Please ask for: Ms Iqraa Malik
Email: iqraa.malik@terraquest.co.uk
Telephone: 01212341390
Our Ref: A/20/21/HH
Your Ref:
Date: 9th February 2021

Application for Planning Permission for Works or Extension to a Dwelling

Development: Two storey side extension and single storey front extension
Location: 43 Old Worthing Road East Preston BN16 1EA

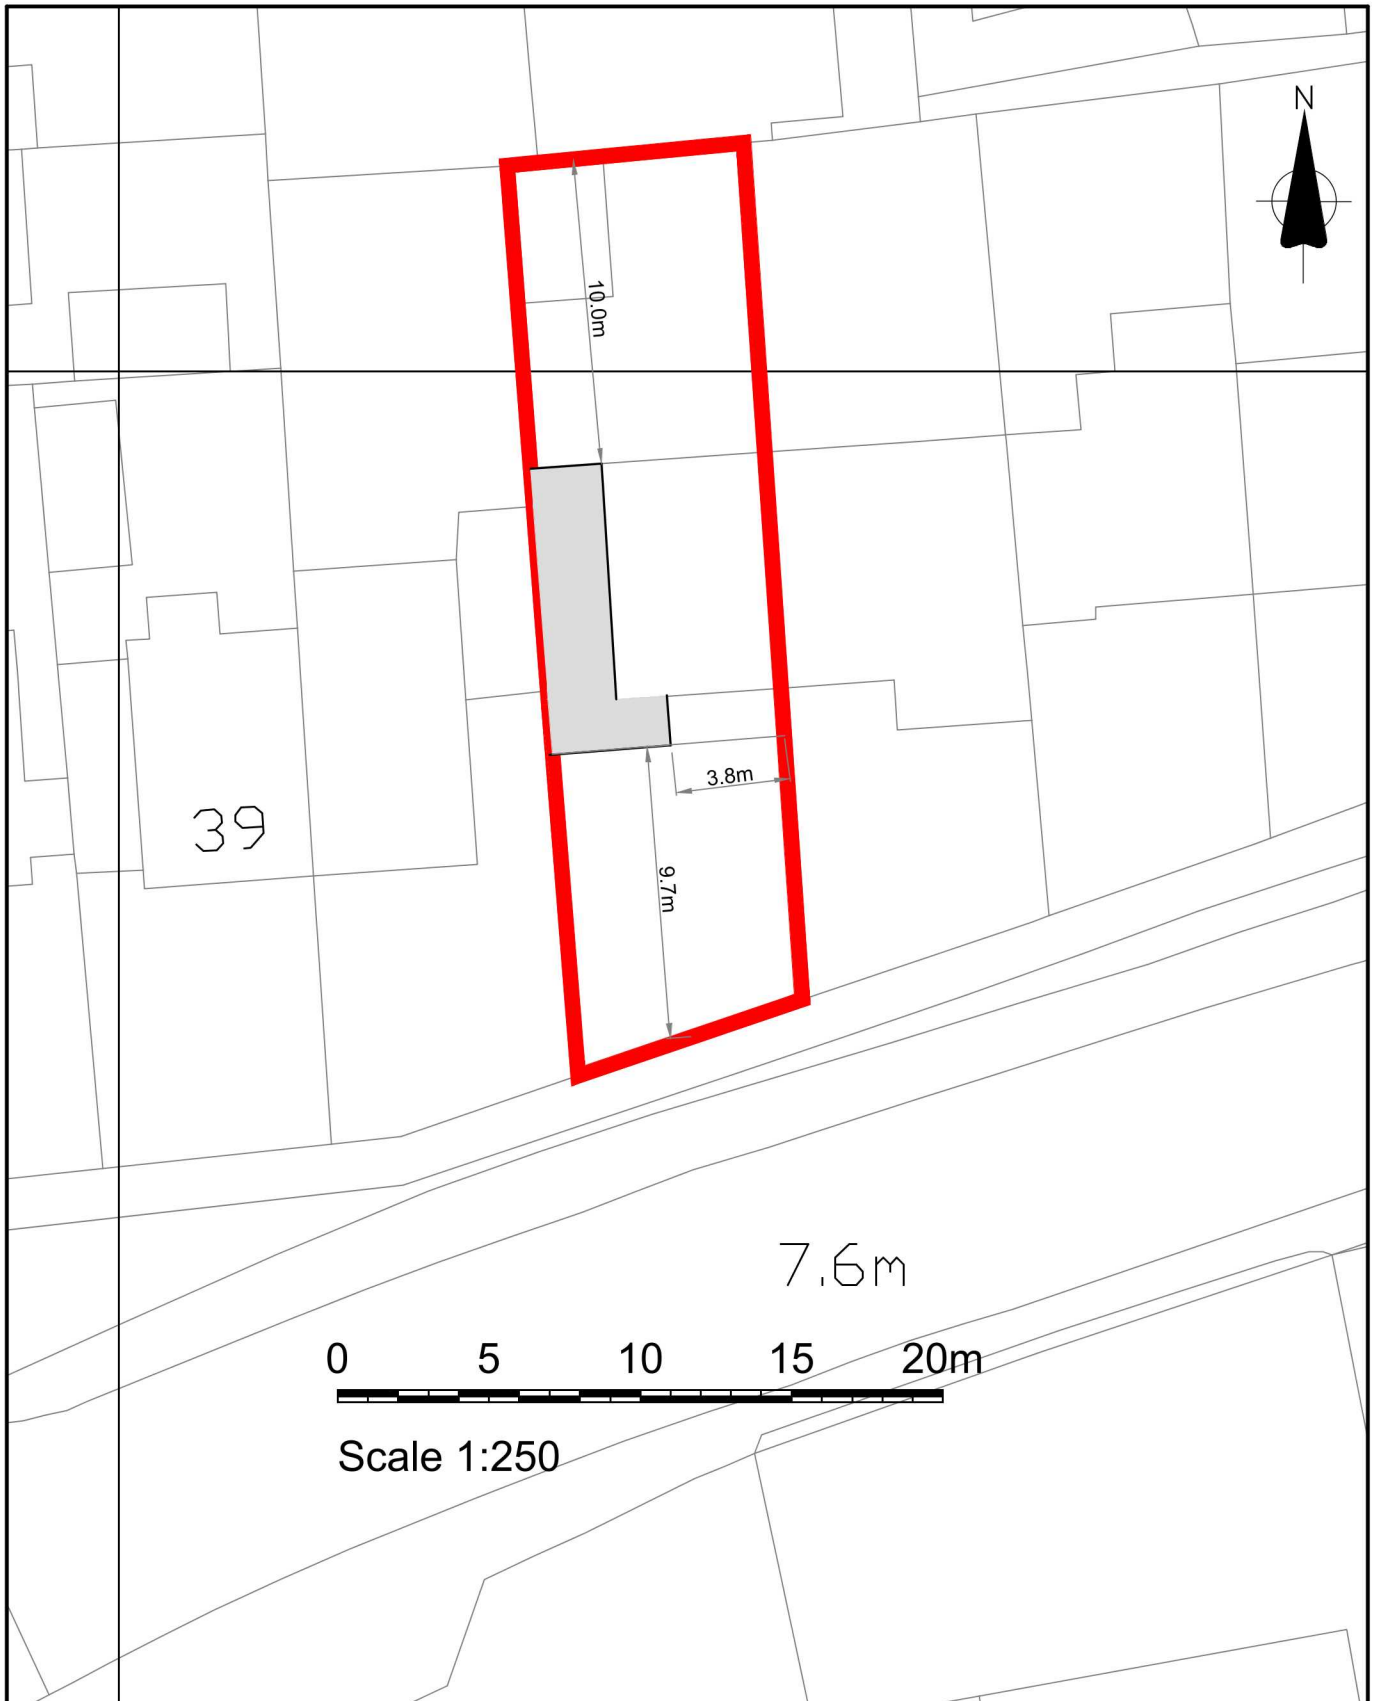
Dimensions: You are required to include dimensions on the block plan from the proposed extensions to all site boundaries.

PROPOSED SIDE ELEVATION - EAST

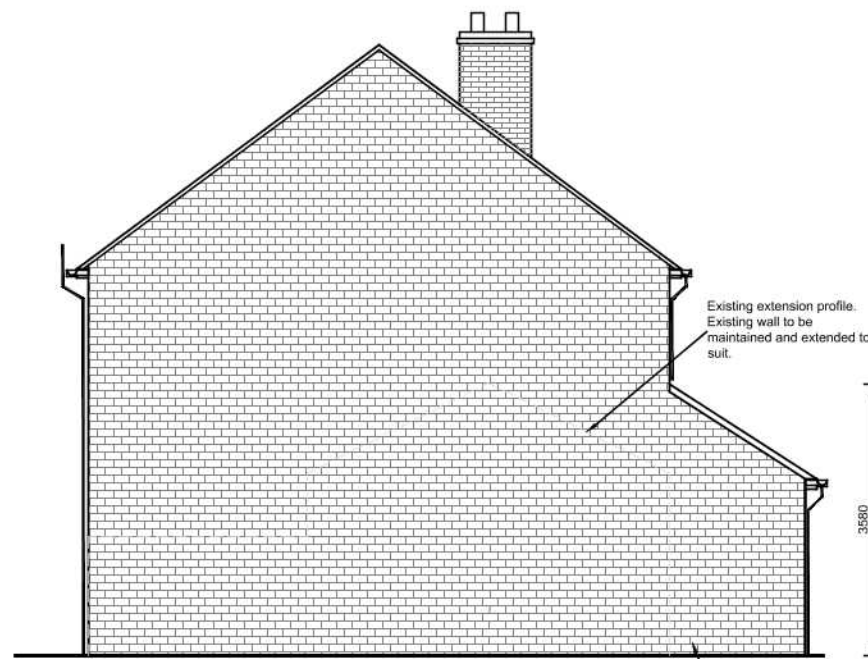
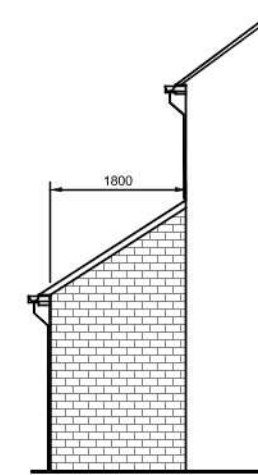
Other Side Elevation: Please provide the other side elevation for this application
